Lime Down

Solar Park

Statement of Common Ground with Natural England (Clean)

Document Reference: EXAM/8.4

Title:
Figure 4-4: Main Infrastructure Layout Changes between PEIR and DCO Application

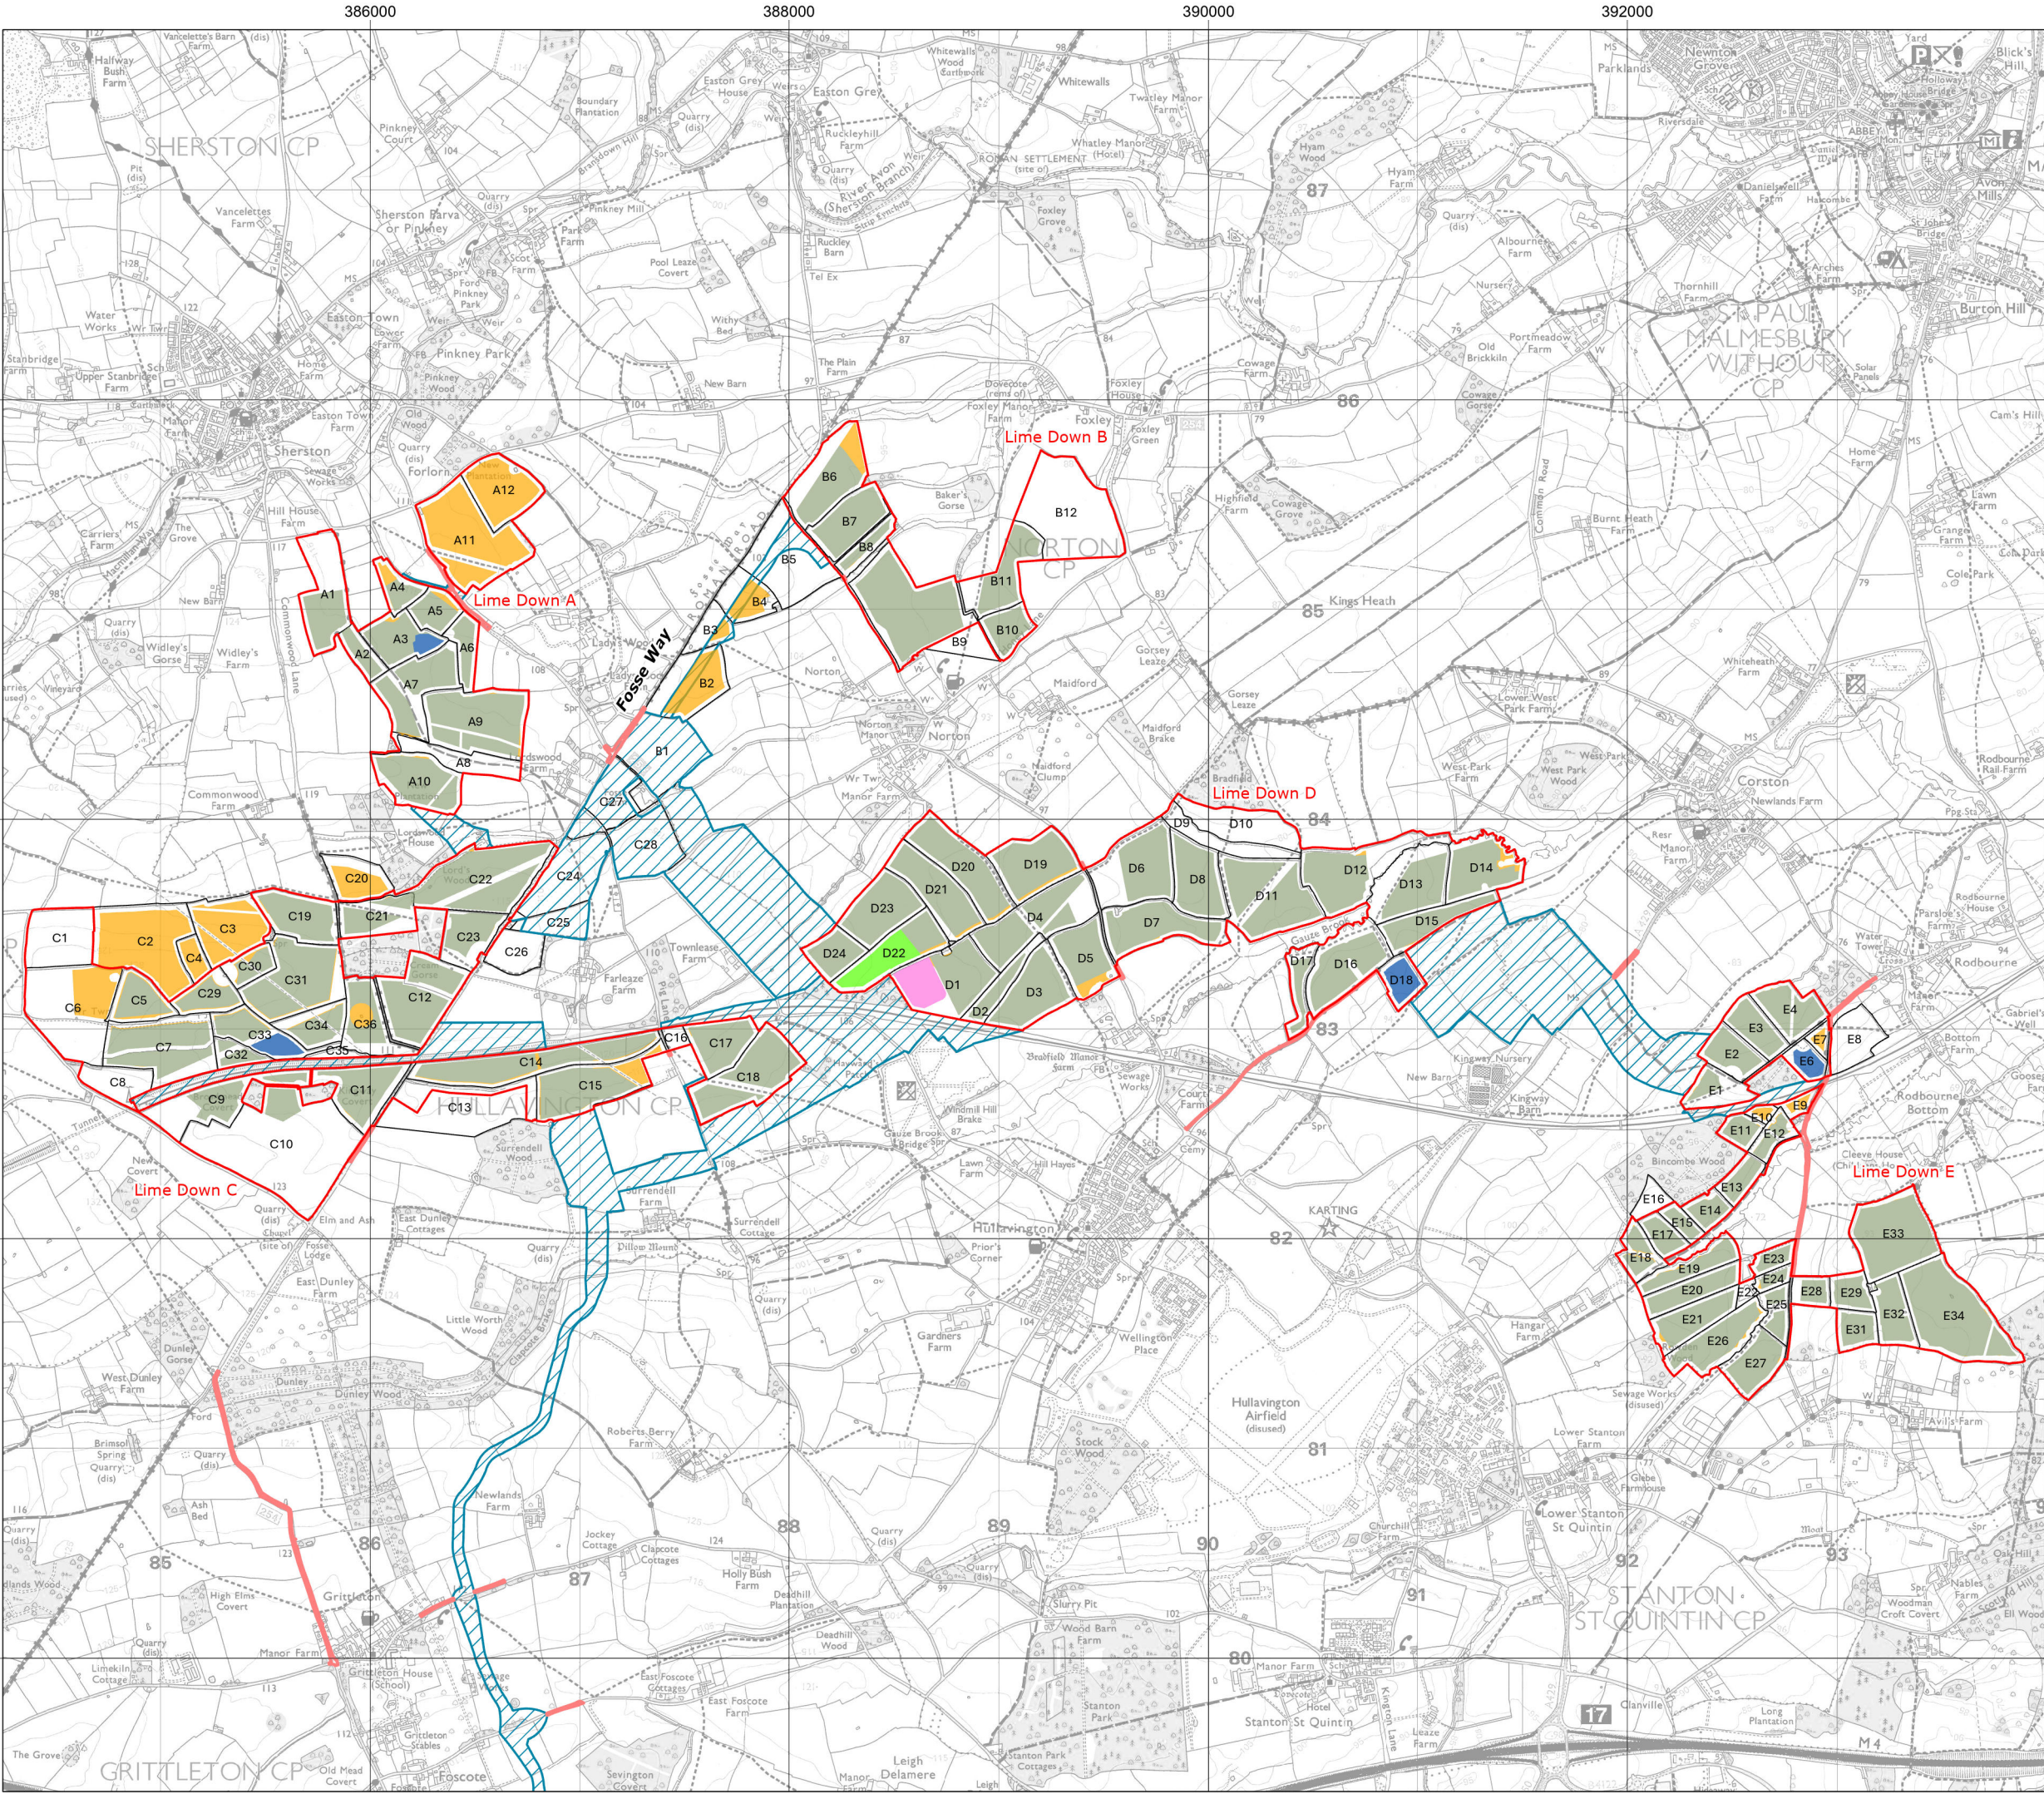
Reference	Sub-topic	NE Position	Applicants Position	Status
3.1.1	Extent of panels within Lime Down C	Recommended that the extent of panels within Lime Down C is reviewed to avoid adverse landscape and visual effects on the CNL. Where panel areas are reduced, this should be used to provide landscape and ecological enhancements, particularly for lesser horseshoe bats.	As shown on the Works Plan, panels will not be located in the parts of fields directly adjacent to the National Landscape boundary within fields C1, C6, C8, and C10 retained clear of panels. Photomontages from 13 viewpoints demonstrates that this limits the landscape and visual impact of the proposed development.	Under Discussion
